Harnett County Government Complex
307 W. Cornelius Harnett Boulevard
Lillington, NC 27546

June 27, 2012

Re: Status of Improvement Permit Application #12-5-29211

PRELIMINARY
PLOT PLAN

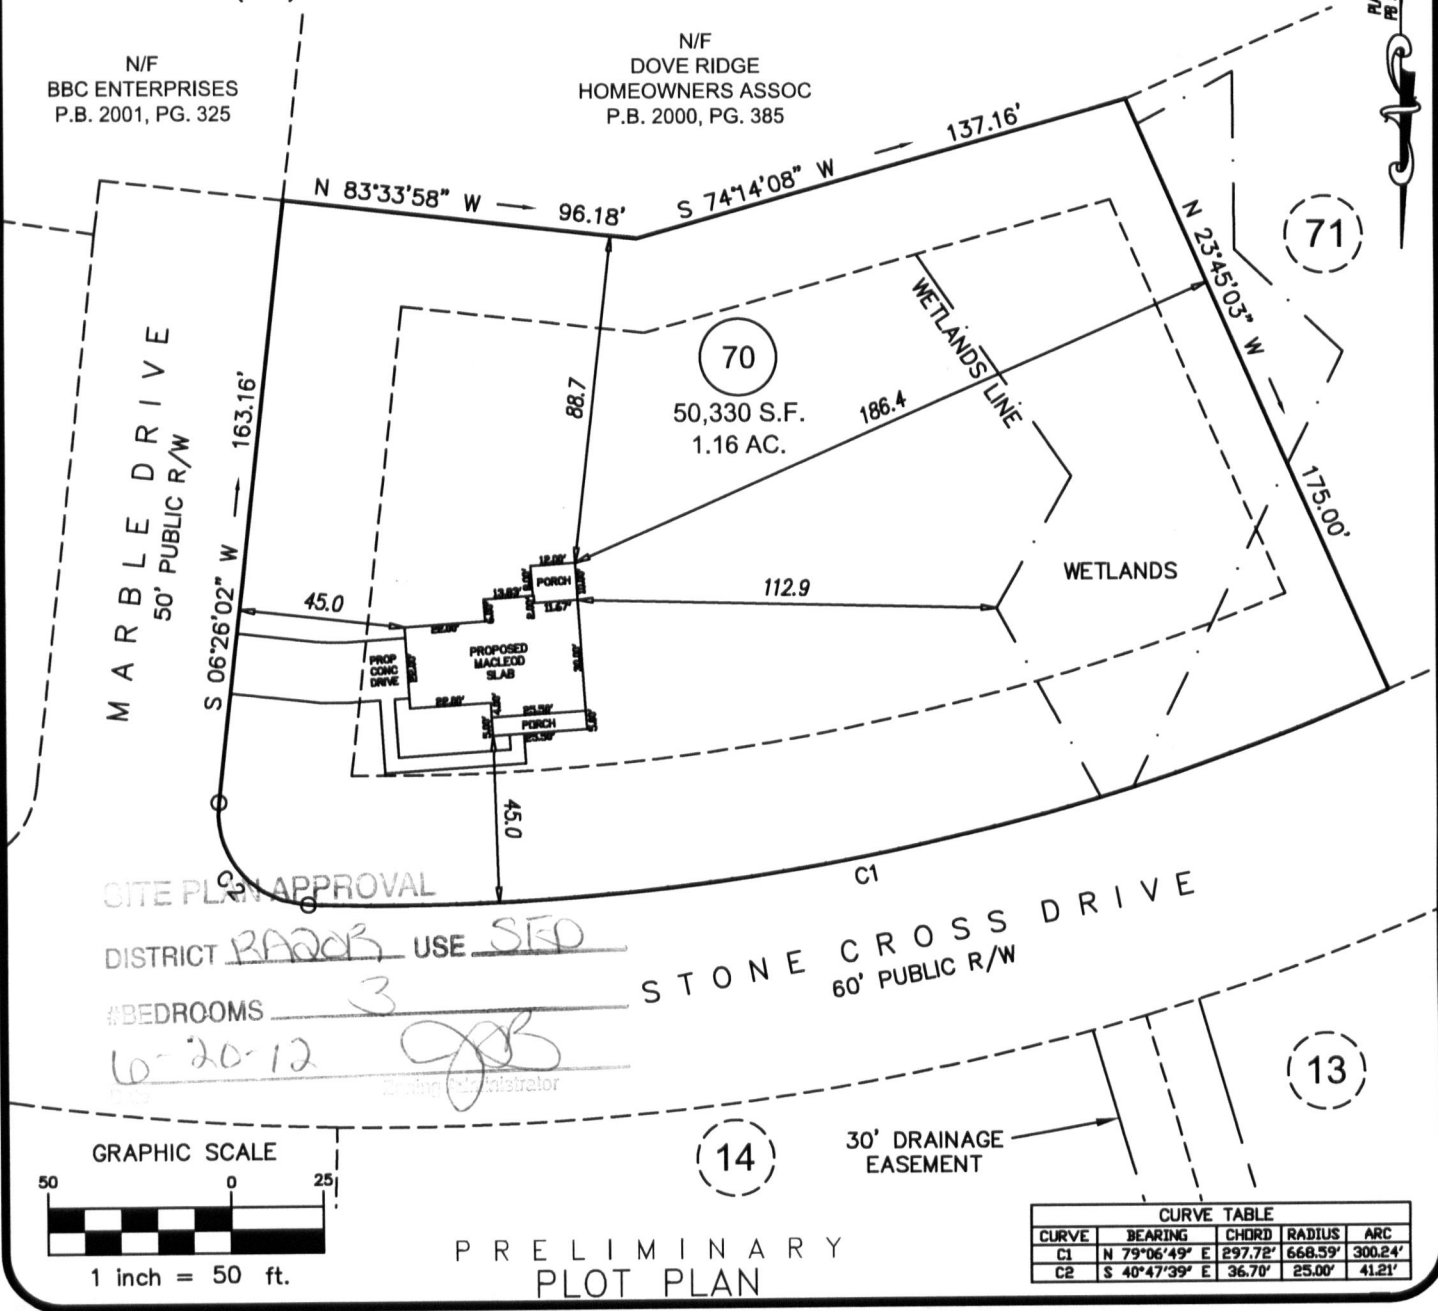
1. Use pink flags to mark property lines and irons that are set by surveyor need to be visible (*\$25.00 fee incurred*)
2. Use orange flags to mark house corners (*\$25.00 fee incurred*)
3. Directions not clear to property (*\$25.00 fee incurred*)
4. Property needs only brush or vegetation removed
5. Driveway not shown on site plan
6. Backhoe pits required
7. **Other – House must be moved out of suitable soil area (see map attached). Submit a revision for re-evaluation to Central Permitting and re-confirm when ready.**
